Appeal Decision

Appeal Ref: APP/A2525/W/15/3032626

Rear of 18 West End, Holbeach, Spalding, PE12 7LW

- The appeal is made under section 78 of the Town and Country Planning Act 1990 against a refusal to grant planning permission.
 - The appeal is made by A W Jackson against the decision of South Holland District Council.
 - The application Ref H09-0016-15, dated 7 January 2015, was refused by notice dated 10 March 2015.
 - The development proposed is a change of use of redundant building to apartment.
-

Drawing
SITE & LOCATION PLANS,
COURTYARD / AMENITY DETAILS.

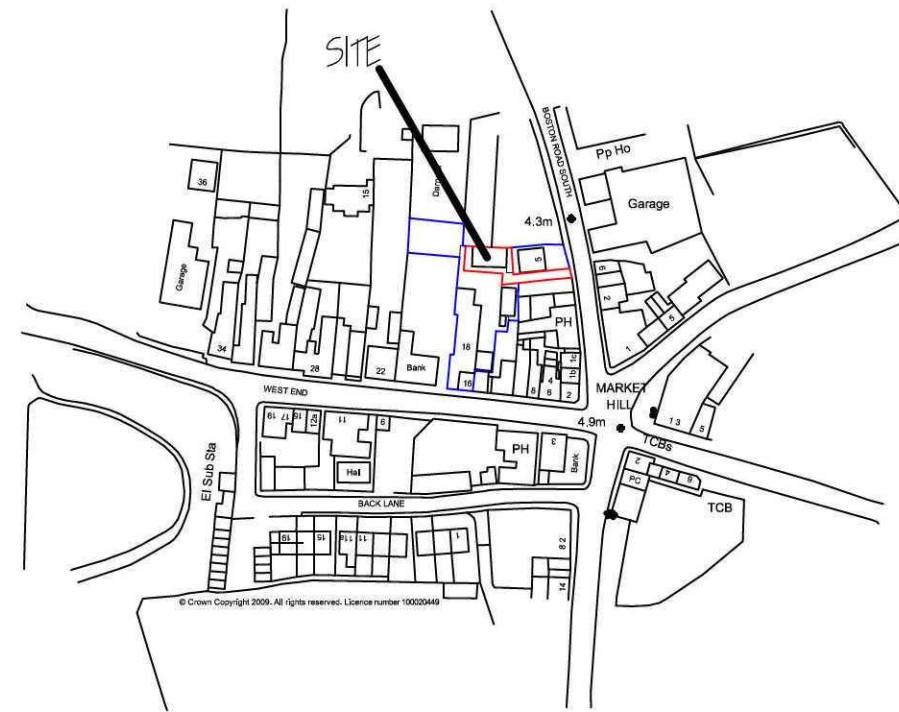
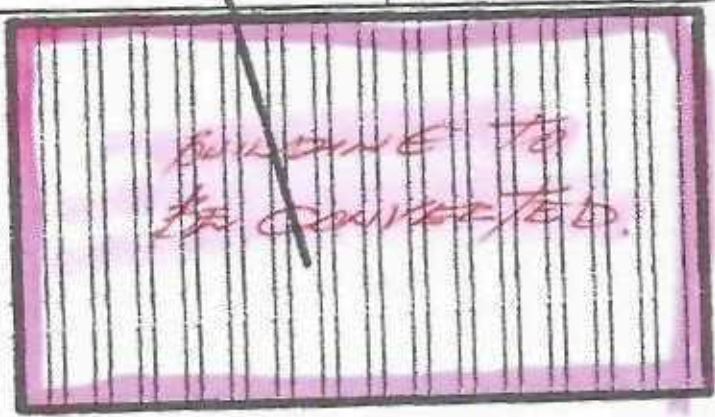
7. I note that the proposed internal space would comply with the Council's Residential Conversions Policy Note 2010 and, in that regard the proposed living accommodation would be acceptable. In addition, the appellant has submitted a plan showing an external area of amenity space on land within his ownership. During my site visit, I observed that this area had been laid out with seating and planting. I consider that it would provide an adequate external space for any future occupants of the apartment, and its retention could be controlled by a planning condition, if the appeal is allowed.
